From: Martin Myers [REDACTED]
Sent: 12 September 2021 14:00
To: Planning.Responses <Planning.Responses@arun.gov.uk>
Subject: Re: [REDACTED] WA/73/21/HH

Martin Myers
1 Barnham Lane, Walberton, West Sussex BN18 0AZ
Object to planning permission

Comment re:WA/73/21/HH:

Proposed New Side Elevations

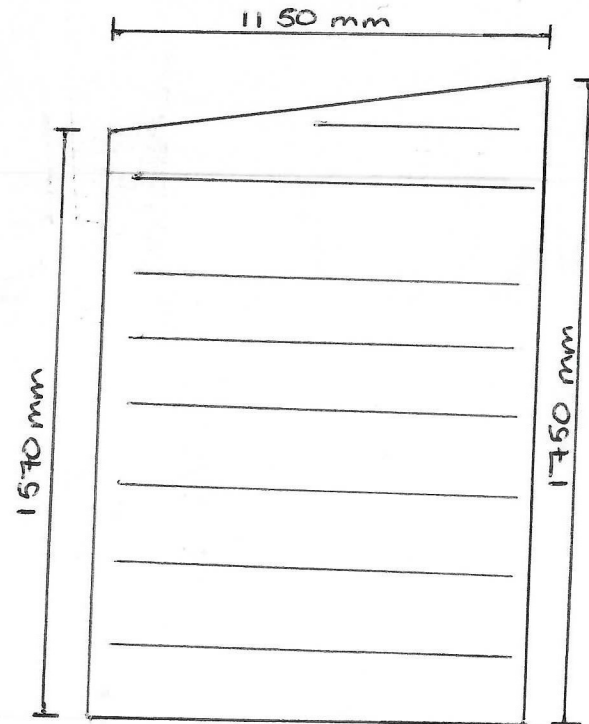
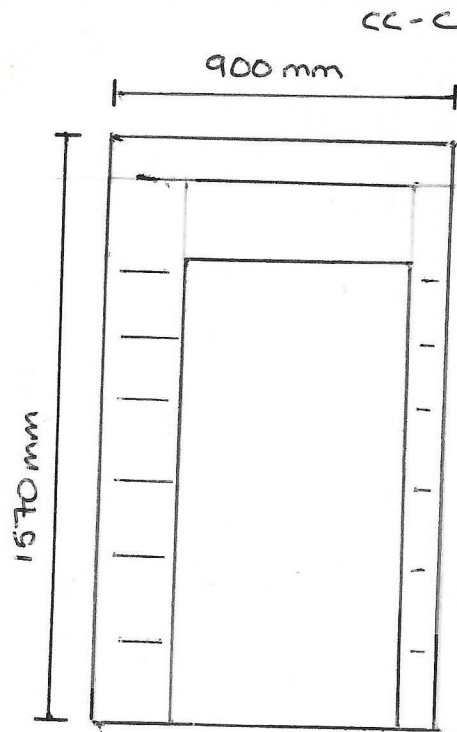
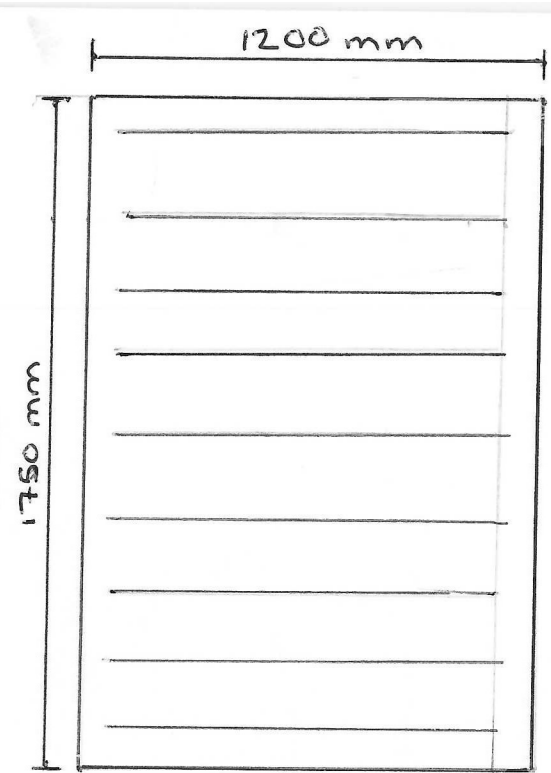
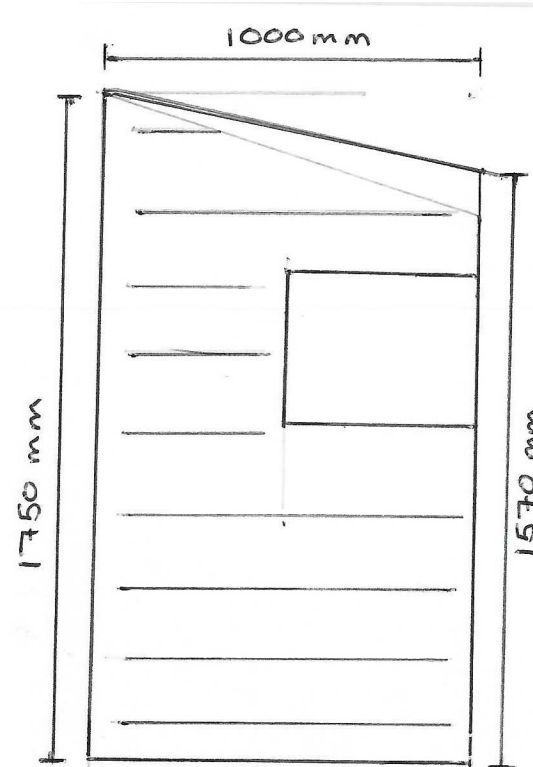
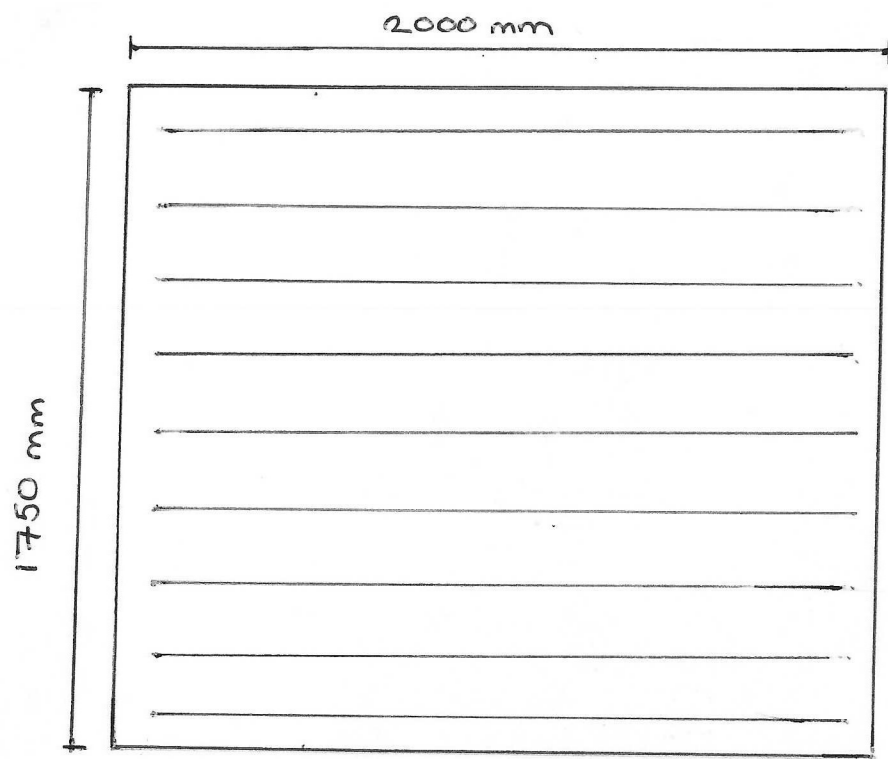
It is very unclear from the plans submitted and associated documents how high the platform of the proposed structure will be (the height of the platform is not specified in the plans). However, from observing the existing structure it appears to be at least 2 metres high, perhaps higher. The 'solid screening' referred to by the applicant and roofing element will mean a final height of around 4 metres plus. This solid screening is in essence fencing panels so the final construction will have the visual affect of raising a 4 metre high fence immediately adjacent to our property. This would be clearly out of keeping with the comparable aesthetics of all the other gardens in the vicinity. This relates to the previous mentioned concerns about loss of daylight/sunlight but is also a concern about a poorly thought out design. Aesthetically this is not a 'treehouse' in the sense of an airy space built amongst woodland, it is actually a rather daunting, over-powering watchtower.

PROPOSED SIDE ELEVATION @ 1:20.

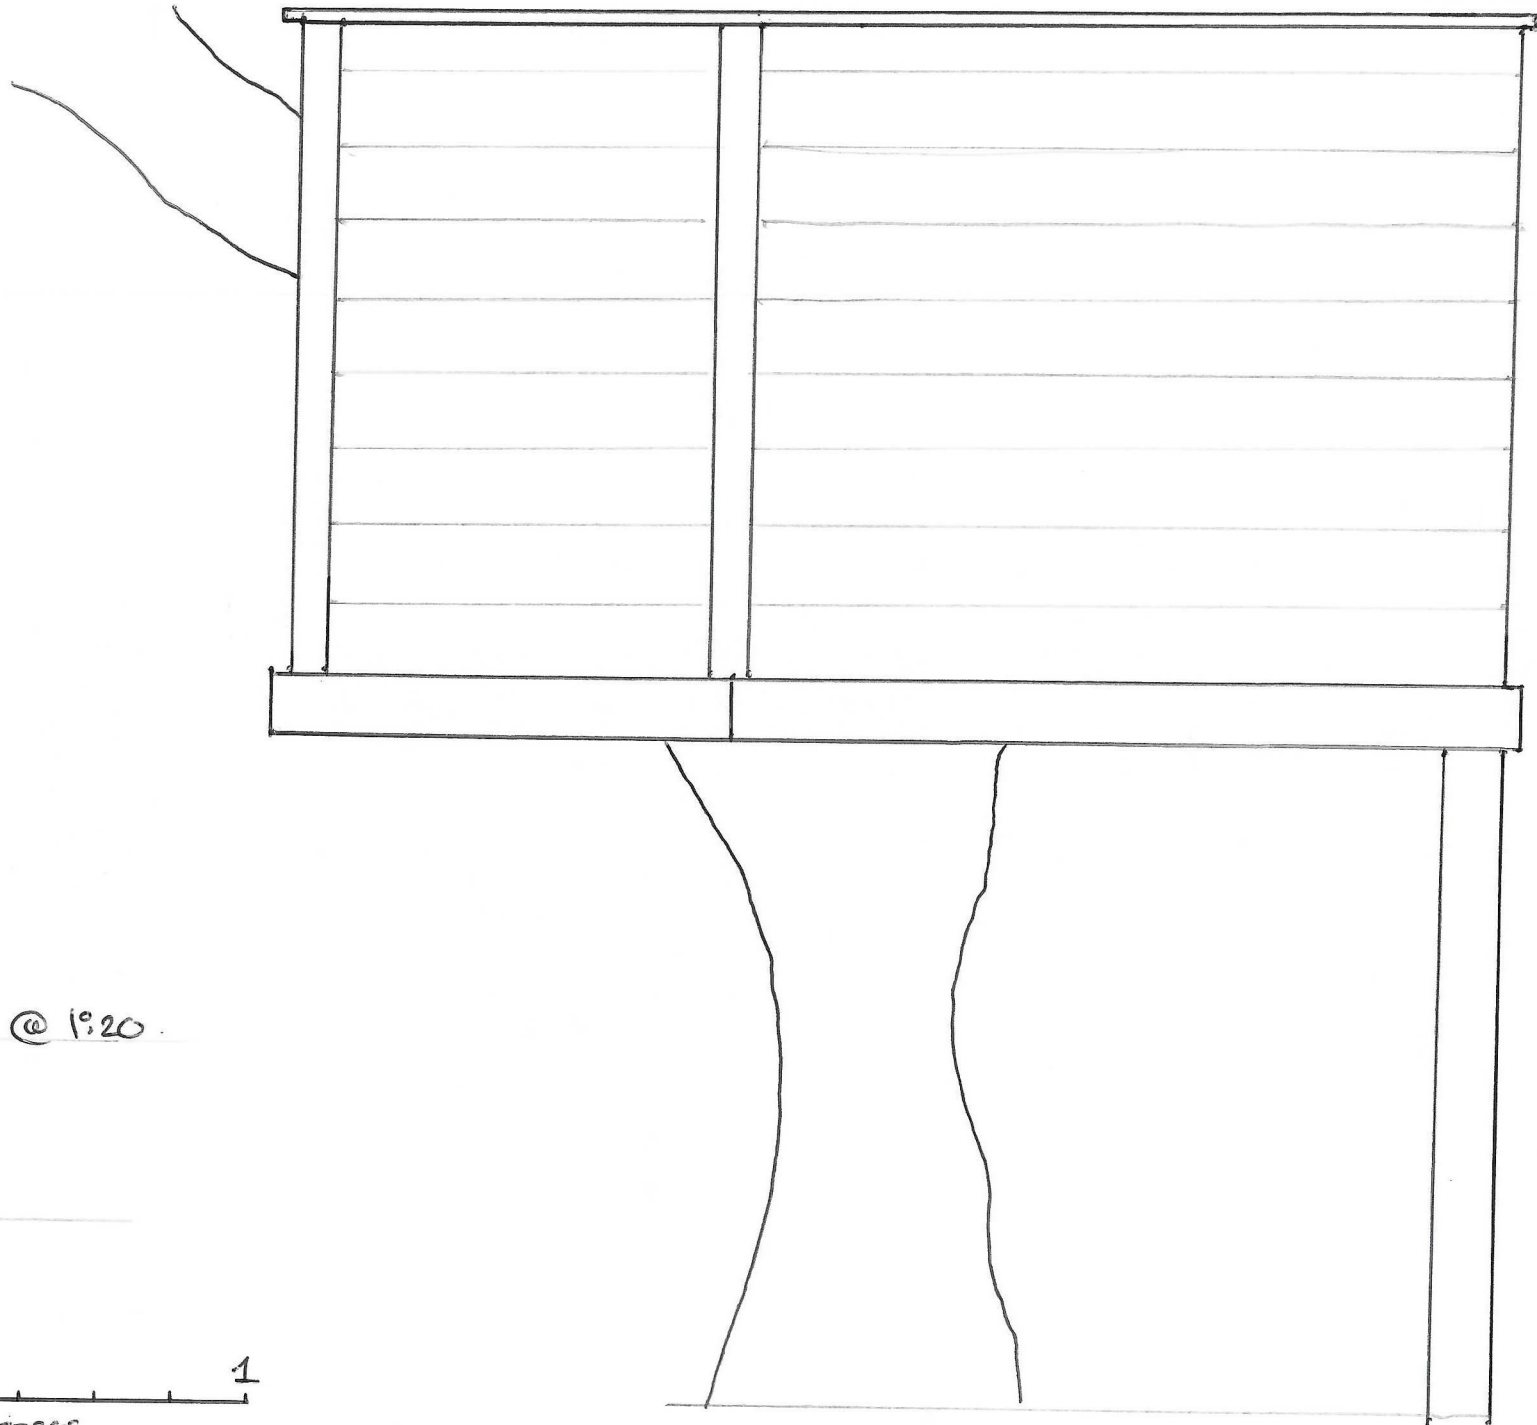
The existing construction allows our neighbours to look directly into our bedrooms as well as directly into other living areas including our bathrooms and utility room. The 'treehouse' also looks directly into our back garden. The extent of this intrusive invasion of our privacy became very clear when I was getting dressed in my bedroom and saw our neighbor staring at me. The new plans do not address our concerns about the intrusion upon our privacy. If anything the extension of 'solid screening', (fencing-type panels), appears more likely to make covert observation into our bedrooms, other living areas and garden more likely. In other words the proposed construction makes it more possible to breach our privacy without our being aware this is happening.
